CITY OF ALBUQUERQUE

February 24, 2022

Re: Jiffy Lube Addition
9386 Coors Blvd. NW
30-Day Temporary Certificate of Occupancy
Transportation Development Final Inspection
Architect's Stamp dated 3-3-21 (C13-D024)
Certification dated 02-18-22

TCL-1

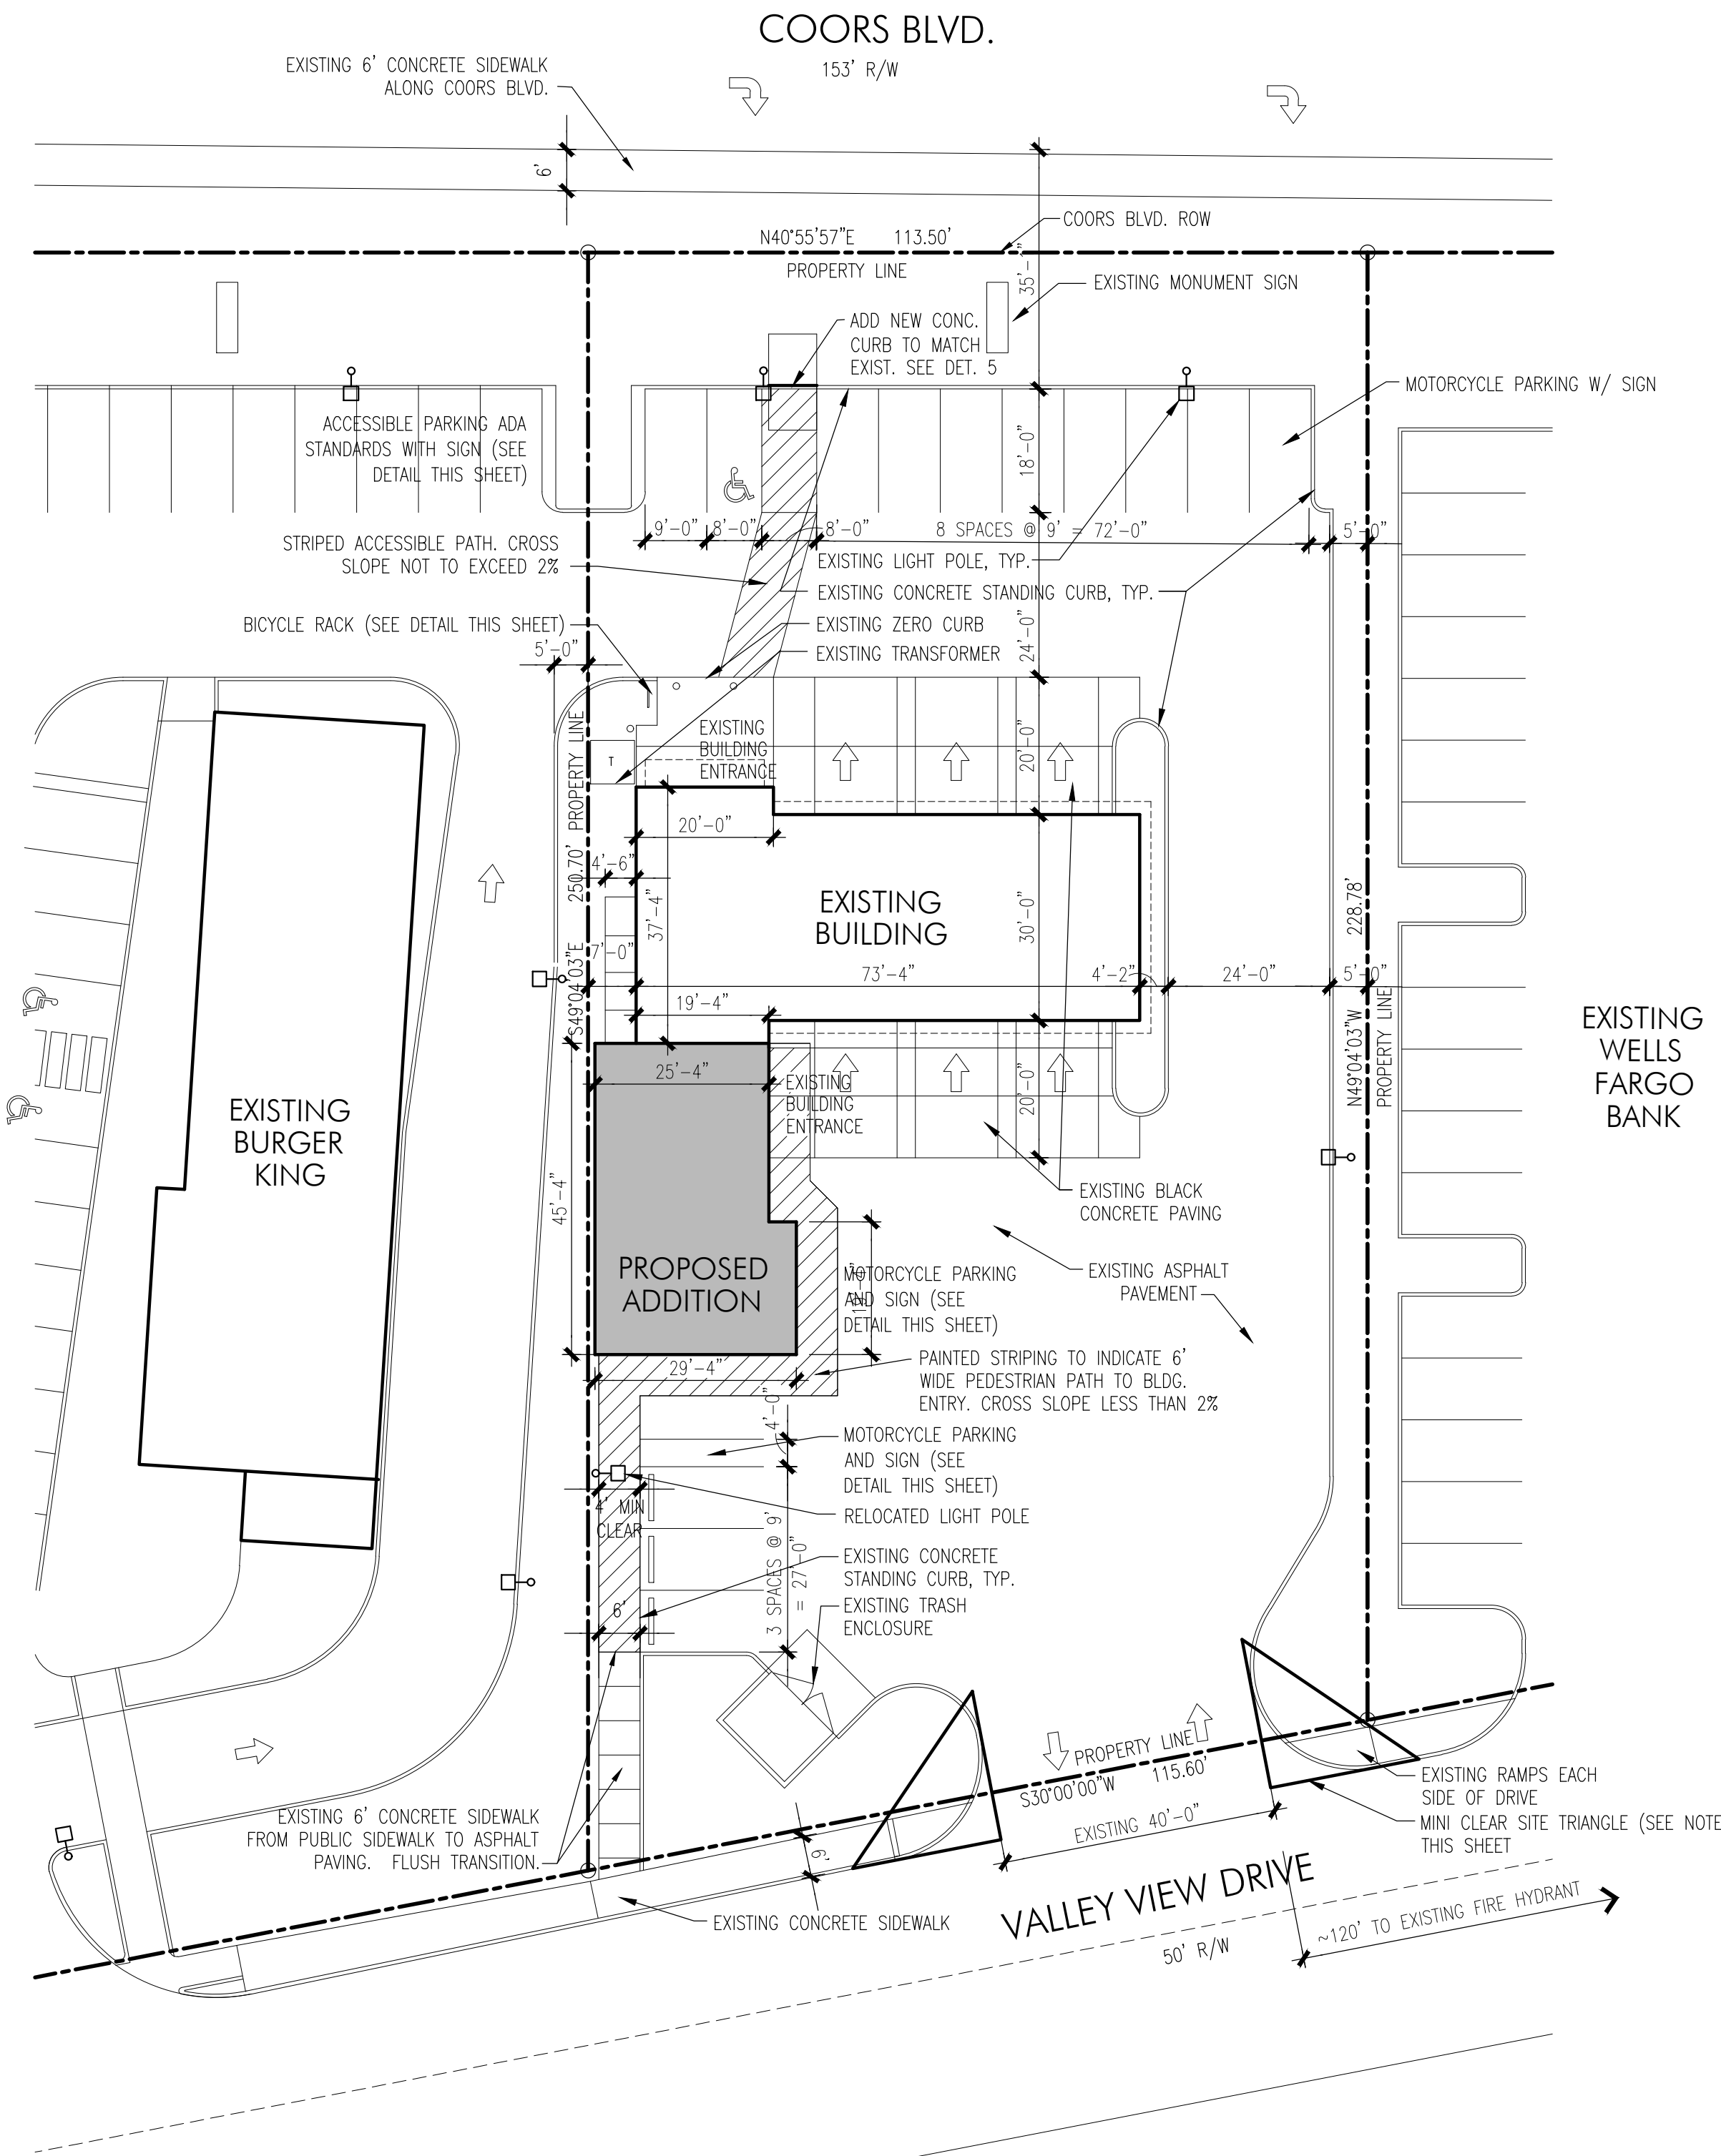
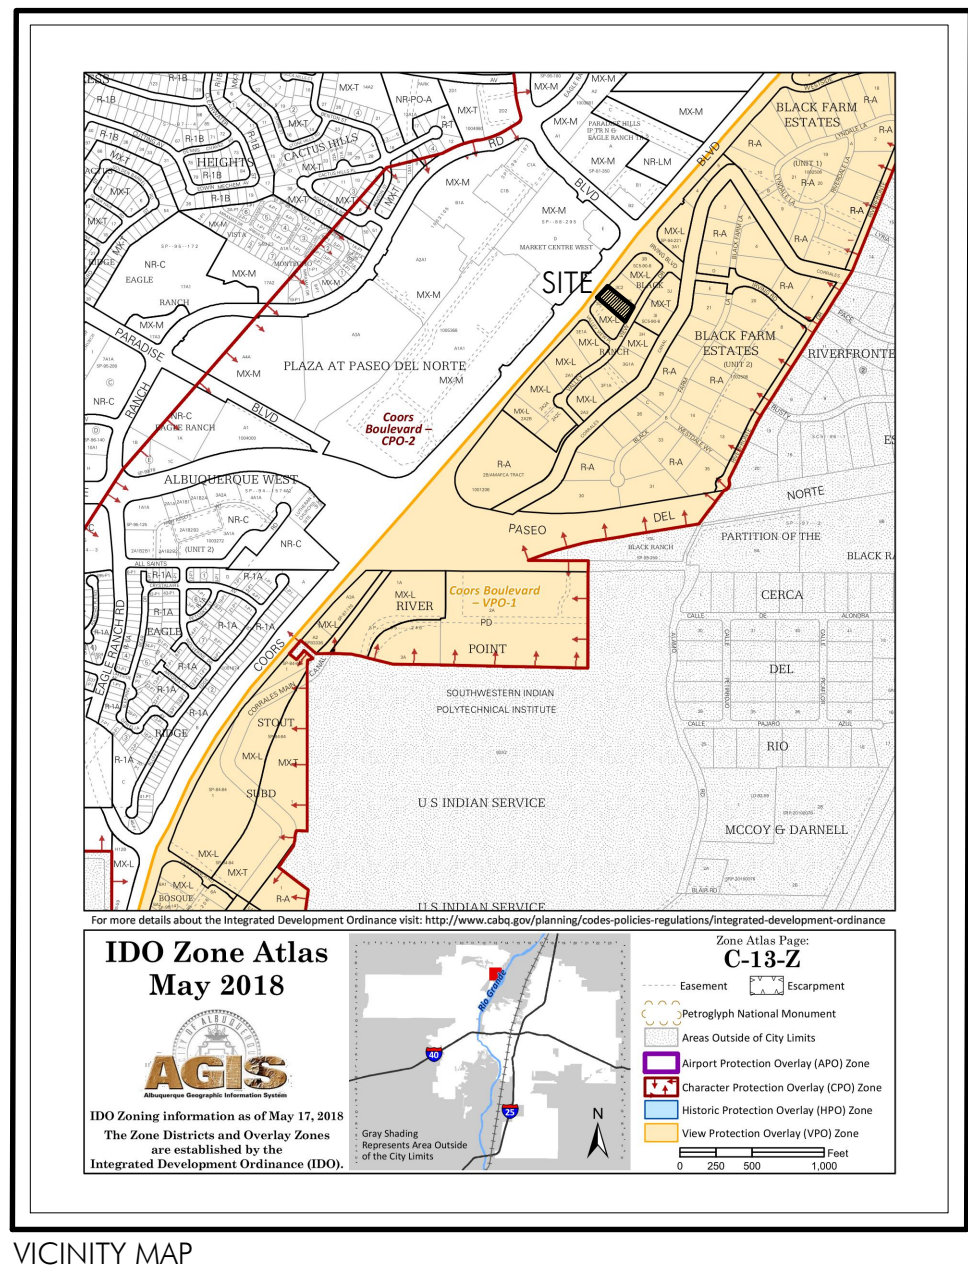
- Please remove the storage that locate by the Trash Enclosure.

Once these corrections are complete, email pictures & redlined TCL plan showing the changes to PLNDRS@cabq.gov, and malnajira@cabq.gov for release of Final CO.
